**WELWYN HATFIELD BOROUGH COUNCIL
EXECUTIVE DIRECTOR - PLANNING, PUBLIC PROTECTION AND GOVERNANCE**

DELEGATED APPLICATION

Application No: 6/2019/0900/EM
Location: 54 Bridge Road Welwyn Garden City AL8 6UR
Proposal: Erection of 2 x two-bedroom semi-detached dwellings with associated vehicular access and parking
Officer: Ms Lucy Hale

Recommendation: Refused

Drawing Number:
IND-754-P02

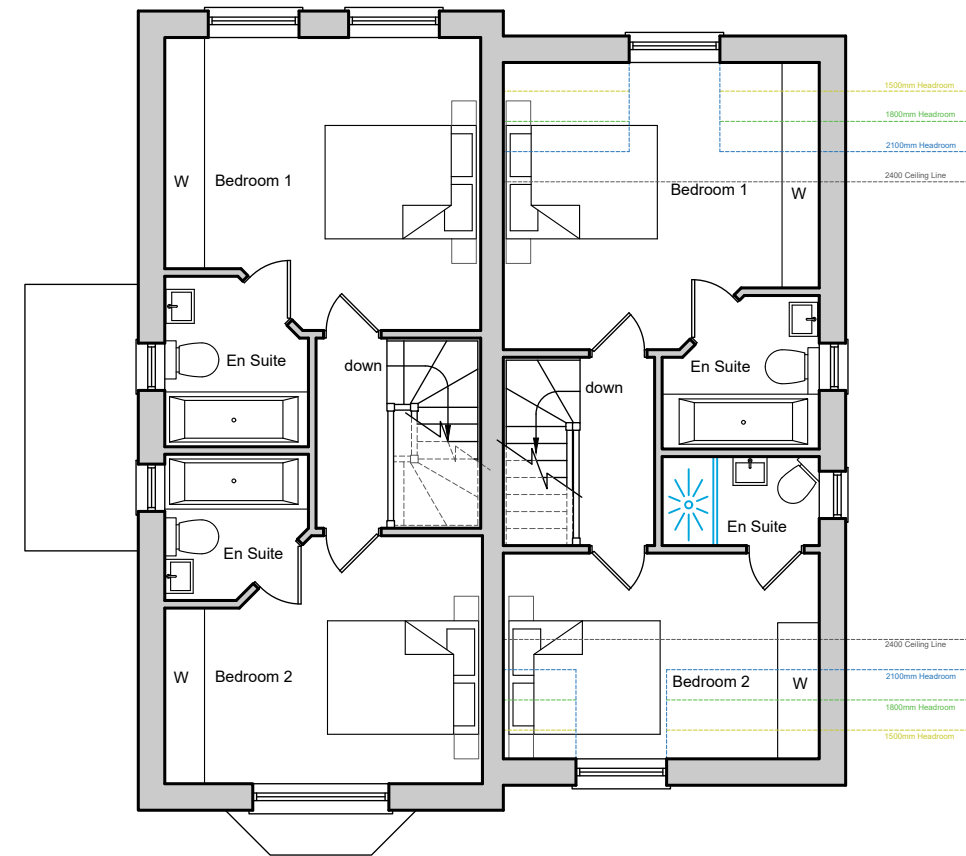
Relevant Policies			
<input type="checkbox"/> EM1 <input checked="" type="checkbox"/> EM2 <input checked="" type="checkbox"/> EM3 Others: EM4			
Considerations			
Design (form, size, scale, siting) and Character (impact upon amenities and values of Garden City)	<p>Policy EM2 of the Estate Management Scheme (EMS) requires proposals to respect the visual appearance of the area in terms of its siting, scale and not result in a visually over prominent or discordant element. Proposals will only be permitted where they do not have a detrimental impact on the amenities and values of the surrounding area.</p> <p>The existing property is semi-detached with a large rear garden. The surrounding area is predominantly residential also with large rear gardens. This part of the Garden City is largely characterised by a formality of layout and architecture including the complete integration of soft landscaping within the built form. This gives the locality a relatively spacious character and appearance, which this property is in keeping with.</p> <p>The proposal seeks to erect two semi-detached dwellings to the rear of No.54. The dwellings would feature a gable roof with red multi brickwork, burnt pan tiles and blackened weatherboarding. The windows would be painted white and feature Georgian glazing. The architectural design and detailing of the semi-detached pair of dwellings would reflect character and appearance of the properties within the streetscene of Bridge Road in accordance with Policy EM2.</p> <p>Notwithstanding this, the proposed footprint and scale of the proposed dwellings would appear large in comparison to the existing property to the front</p>

<p>on the site. Furthermore, the proposed dwellings, together with the existing dwelling, would appear excessive and overdeveloped in comparison to the size of the plot, which would be out of keeping with the immediate character of the area. The outcome would be that the proposal would have a cramped nature and would impact detrimentally on the overall spacious character and appearance of the locality as a whole. This harm would also be exacerbated as the development would be visible from public vantage points.</p> <p>It is noted that a previous application under reference W6/2014/2503/EM was granted consent for a pair of semi-detached dwellings to the rear of No.52 and No.54. In comparison, this proposal seeks to erect two dwellings within one plot instead of the built form across two plots, thereby resulting in the existing and proposed dwellings appearing contrived and cramped within the new reduced plot, which would be out of keeping with the special character and context of the area, contrary to the objectives of Policy EM2.</p>

1. The proposed dwellings by virtue of their scale and siting, would represent an unduly cramped and over intensive form of development on the site, poorly related to the established character and form of this part of Welwyn Garden City. This harm would be exacerbated as the development would be visible from public vantage points. The proposed development would fail to maintain or enhance the amenities and values of this part of the Garden City, contrary to Policy EM2 and EM3 of the Welwyn Garden City Estates Management Scheme.

Drawing Number:
IND-754-P20

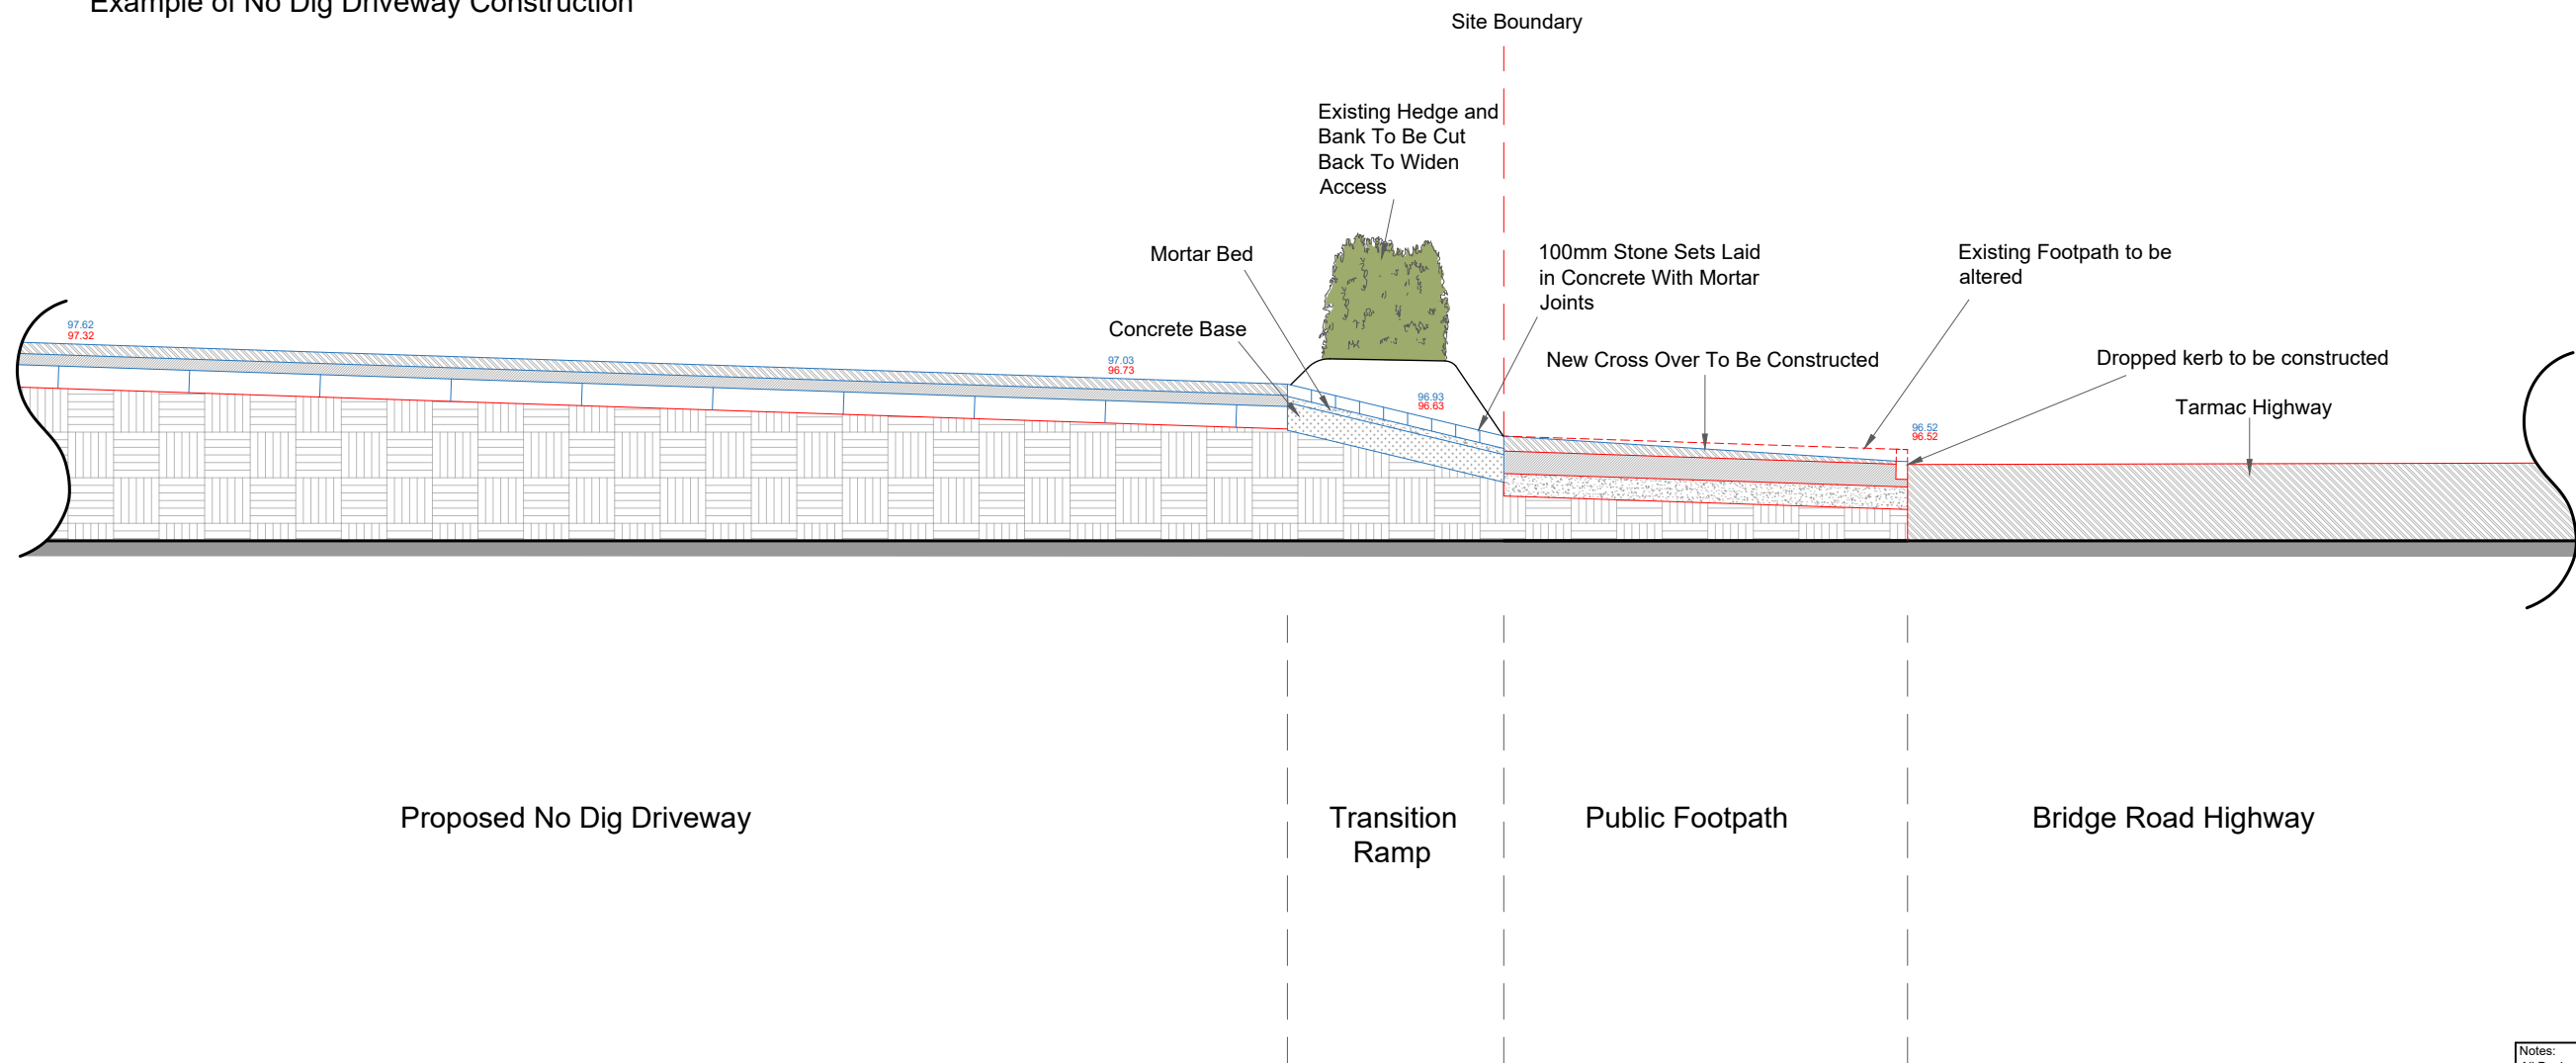
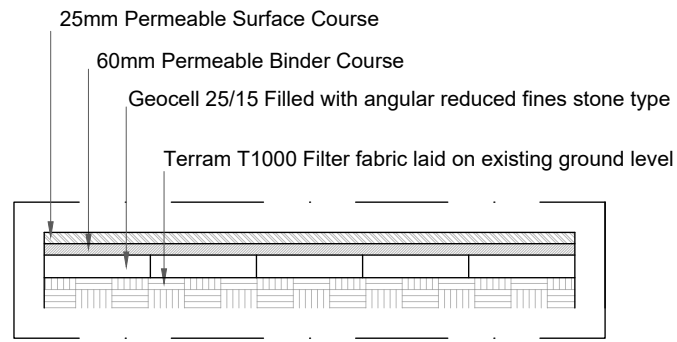
The proposal seeks to install a new vehicle access, turning area and parking spaces to the rear of No.54. A 4.8 metre wide access is proposed which would involve part removal of the existing front boundary hedge. The access on site would be maintained at 4.8 metres wide for the first 14 metres and is proposed to wrap around No.54, reducing to 3 metres in width to the turning area and car parking spaces. The proposed hard surface cumulates to a substantial amount on site. When compared to the existing site, which does not benefit from an access or on-site car parking, the proposed hard surface would be significant.

In this instance, the site is unique as joins a public footpath both to the side and rear. The site is therefore largely exposed from public vantage points. The public footpath is extensively used by local residents to access Sherrardspark Wood and as a cut through from the residential houses behind the site to the Town Centre. The landscaped greenery of the rear gardens that adjoin the footpath contribute to the character and appearance of this area. The introduction of the amount of hard surface alongside this footpath, combined with the introduction of parked cars would be out of keeping with the character of this area.

Furthermore, the proposal seeks the removal of 4.8 metres of front boundary hedge which is considered to be a significant amount. The front boundary hedge contributes to the landscaped appearance of Bridge Road and its removal, alongside the large amount of hard surface that would be visible from the road frontage, would significantly alter the soft landscaped character of the frontage of the site which contributes to the amenities and values of the streetscene to which it is located.

2. By virtue of the amount of hard surface and removal of front boundary hedge, the proposed development would fail to retain an acceptable balance of hard and soft landscaping thereby failing to preserve the unique character and appearance of the site and its locality as required by Policy EM3 and EM4 of the Estate Management Scheme. The proposal would therefore result in harm to the amenities and values of this part of the Garden City.
